City of Albuquerque Stormwater Construction Site Inspection Report

ESC File No.	E17/E011B	Project Name:	XRAMM Jefferson Office		
NPDES Id. No.	NMIR1004F1	Location:	5800 Jefferson St NE		
2/1/2023	Owner	Contractor			
Operator	Jefferson 25 XRAY QOZB, LLC	Enterprise Builders			
Contact name & title	Jeff Jesionowski	David Lundsten			
e-mail	jeff@amcdevelopment.net	dlundsten@ebnm.com			
Contact Phone #	259-0991	452-7639			
COA Inspector	Doug Hughes	Start/End Time:	8-9 am		
Construction Phase:	Lot 1B1 building and parking complete needs landscaping, Lot 1A1 dirt.				
Type of Inspection:	Regular	Storm Event	Post Storm Event >0.25"	311/Complaint	Follow Up
Weather at time of inspection?	Clear		Temperature: ~	35	
Estimated date of last storm 0.25" or greater	12/4/2022

SHEET TITLE
Sheet Name
 EROSION AND SEDIMENT CONTROL PLAN

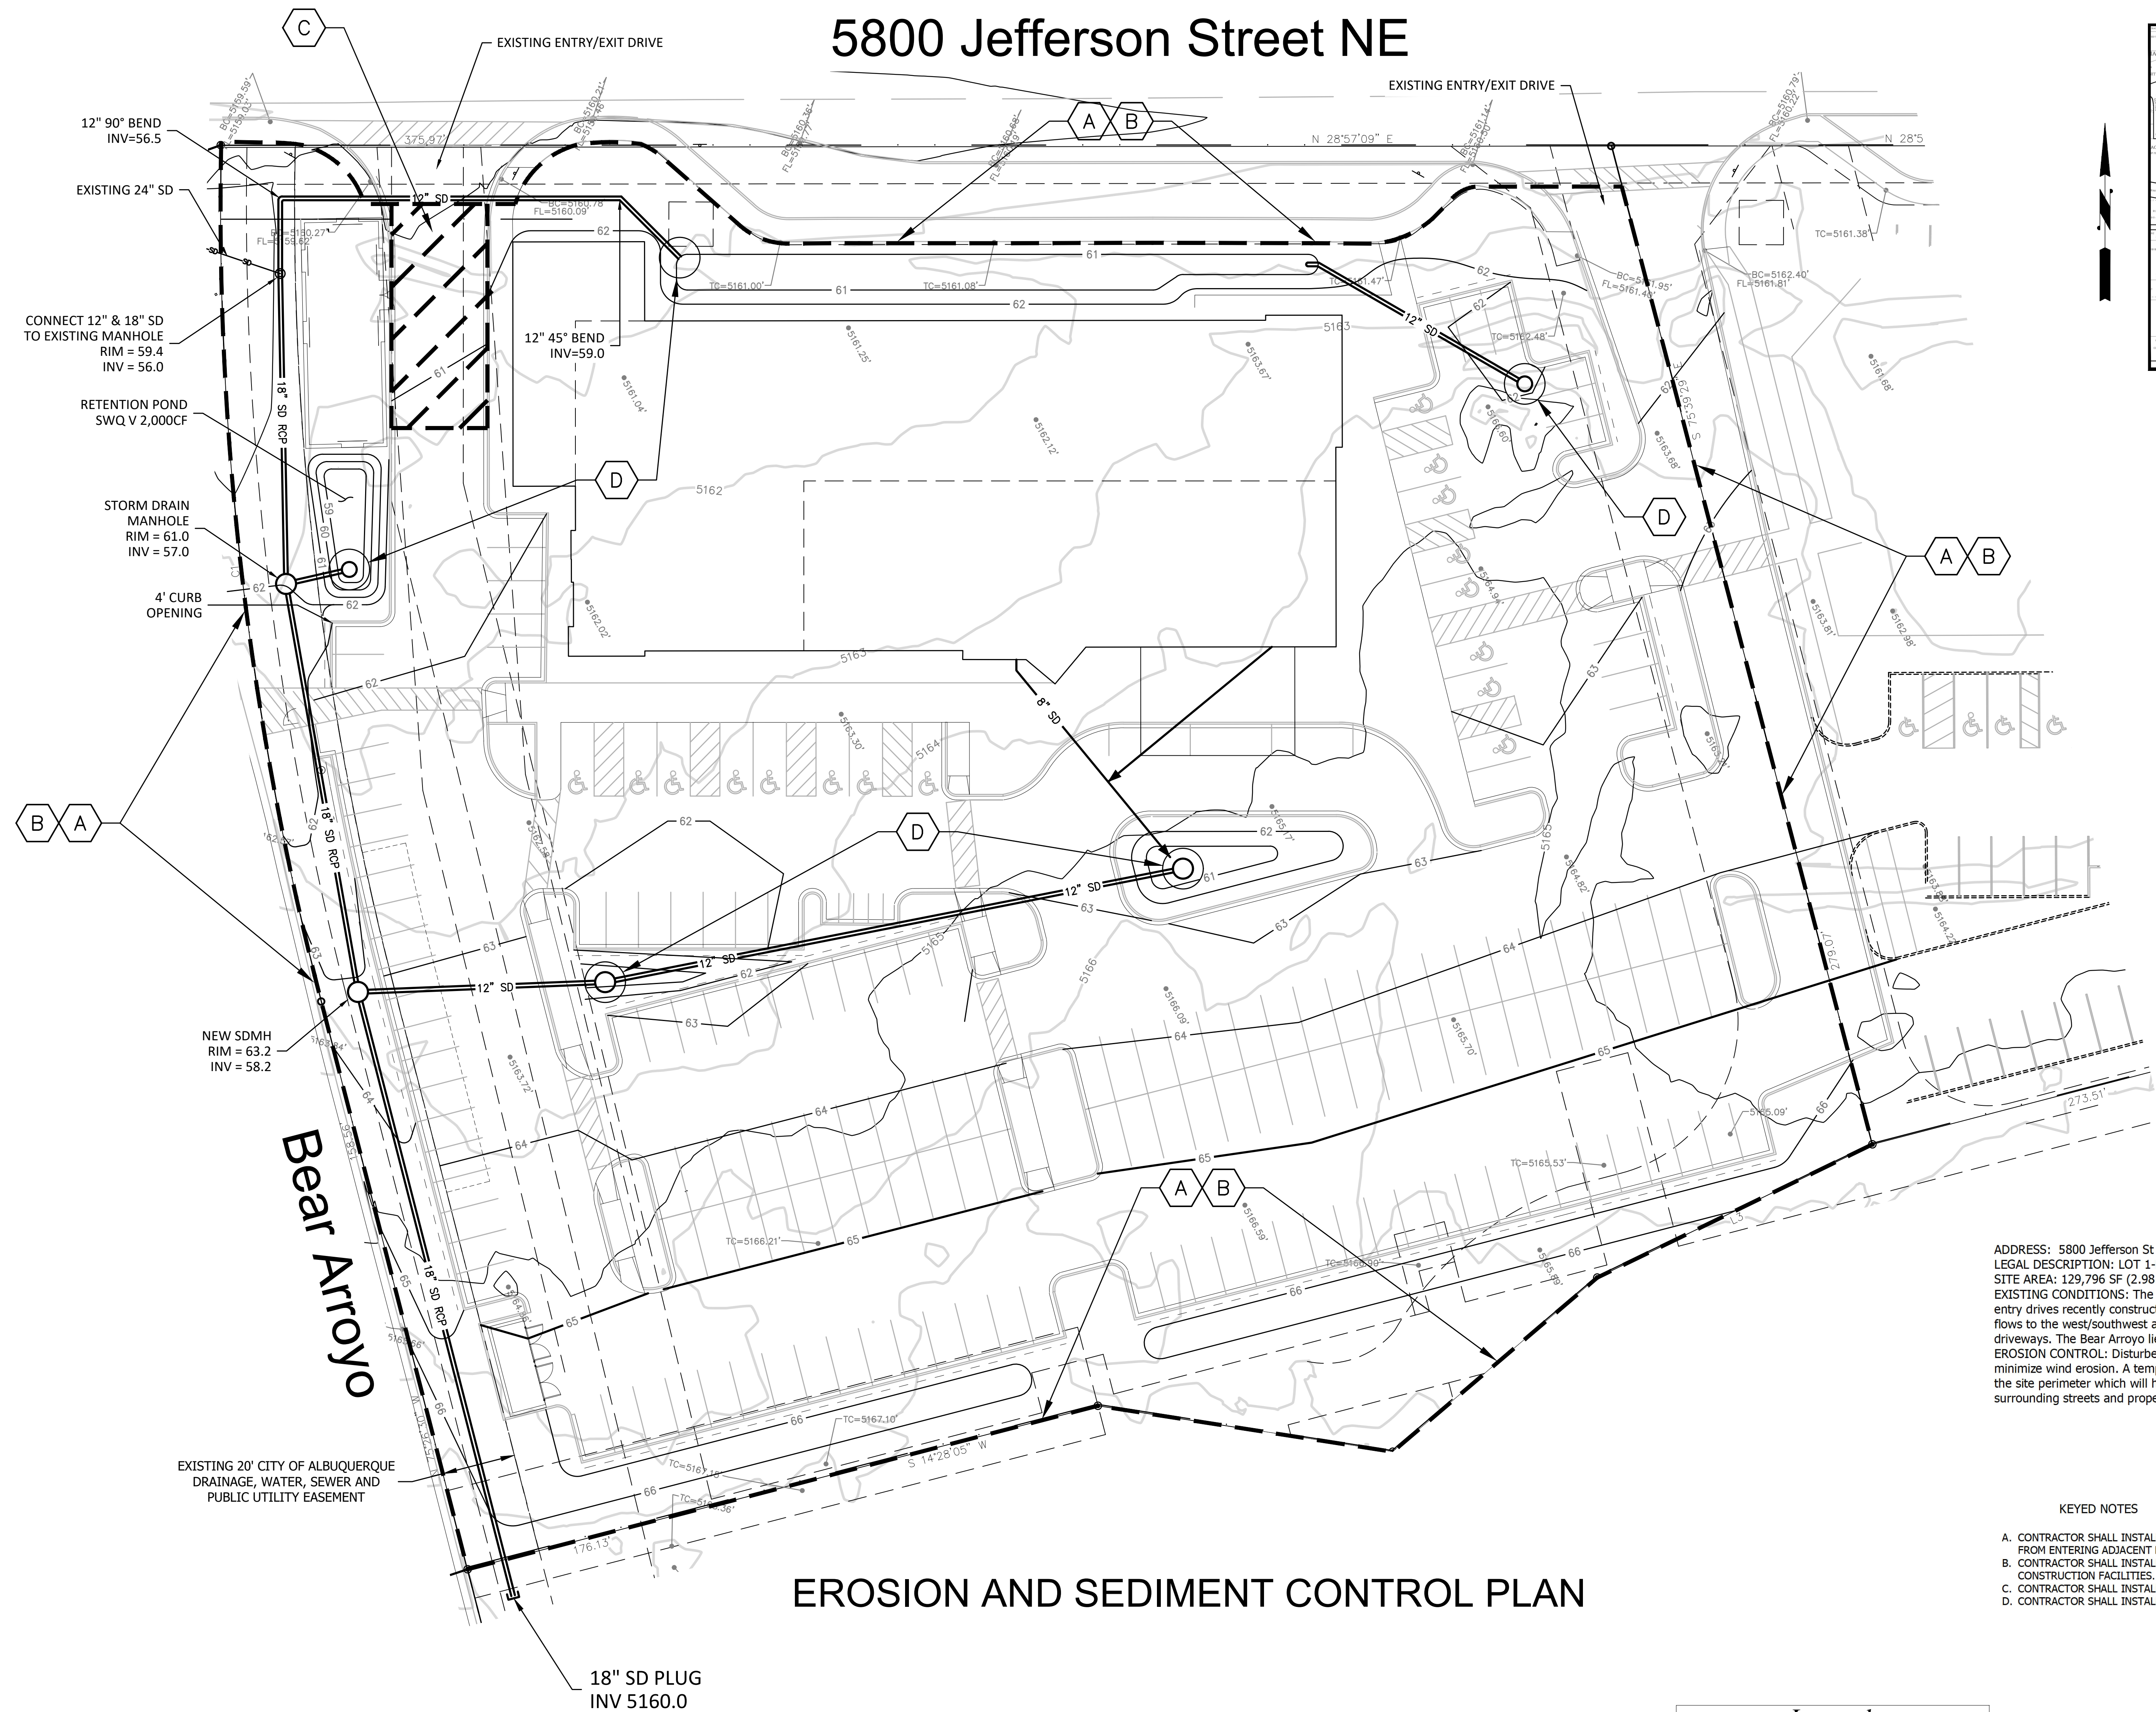
Item Number	Deficiency/ Corrective Action			
1	The SWPPP isn't up-to-date as required by CGP 7.1. The SWPPP map didn't accurately show the limits of disturbance, silt fence locations. The NOI and CGP in the SWPPP were expired.			
2	Washout - Concrete, stucco, and paint wash water must go into lined container. Remove all contaminated soil.			
3	Waste container full and needs cover.			
2.1	Discharge off site? (Y/N)	no		
4	Self Inspection Reports	n/a	Latest report Date:	2/14/2023
